From: Sue Howell
Sent: 11 September 2018 12:15
To: Planning.Responses
Cc: Simon Davis
Subject: RE: Planning Consultation on AL/60/18/DOC

Comment from Greenspace

Site Address: Sack Lane Dairy Sack Lane Aldingbourne PO22 9PD

Description of Works: Application for approval of details reserved by conditions imposed under planning permission AL/58/17/PL relating to condition No. 4 (Surface water drainage scheme), 5 (Contamination), 6 (Hard and Soft landscaping), 7 (materials), 8 (details of new screen walls and fences), 11 (Secure & covered bicycle stores), 12 (details of storage of waste and recycling) & 17 (external lighting)

Drawing Number: 2015/15/25 Rev.

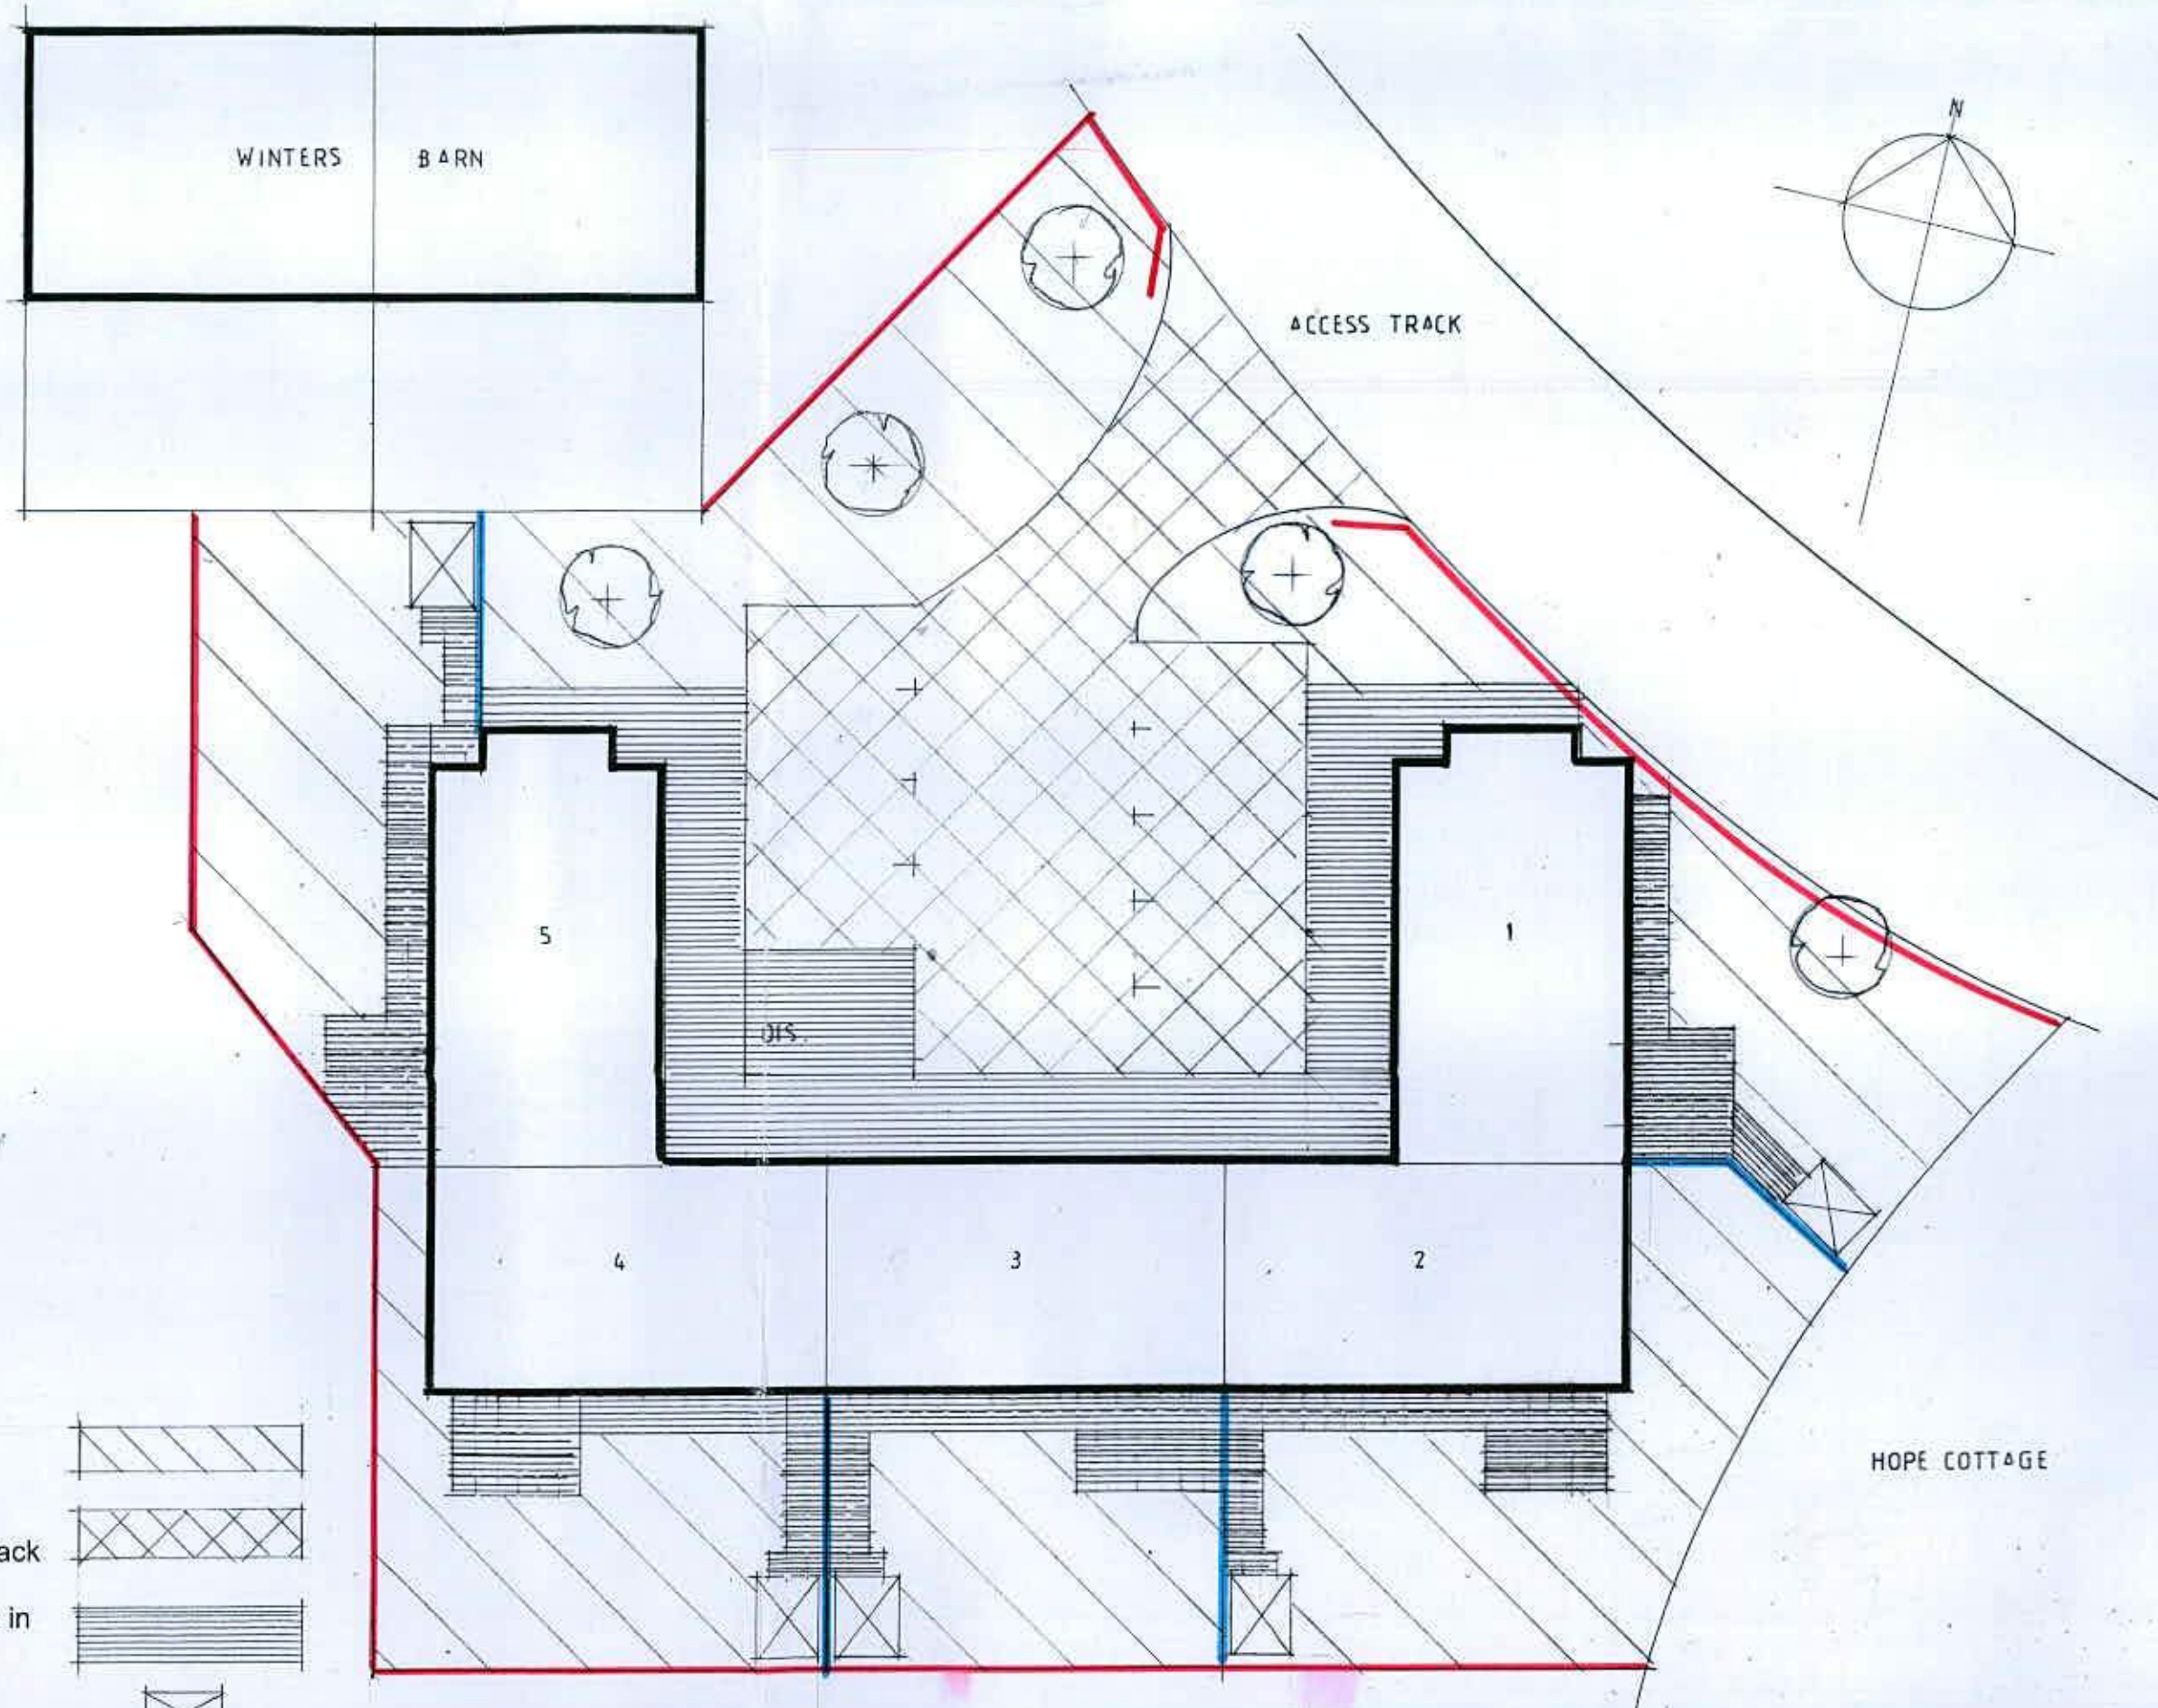
Further to submission of landscaping plan drawings no 2015/15/25, we can confirm that the information supplied does provide planting detail which is fitting for location with sufficient detail and therefore we would **recommend the discharge of Condition 6 Landscaping** reserved by condition imposed under planning approval AL/58/17/PL on this application AL/60/18/DOC.
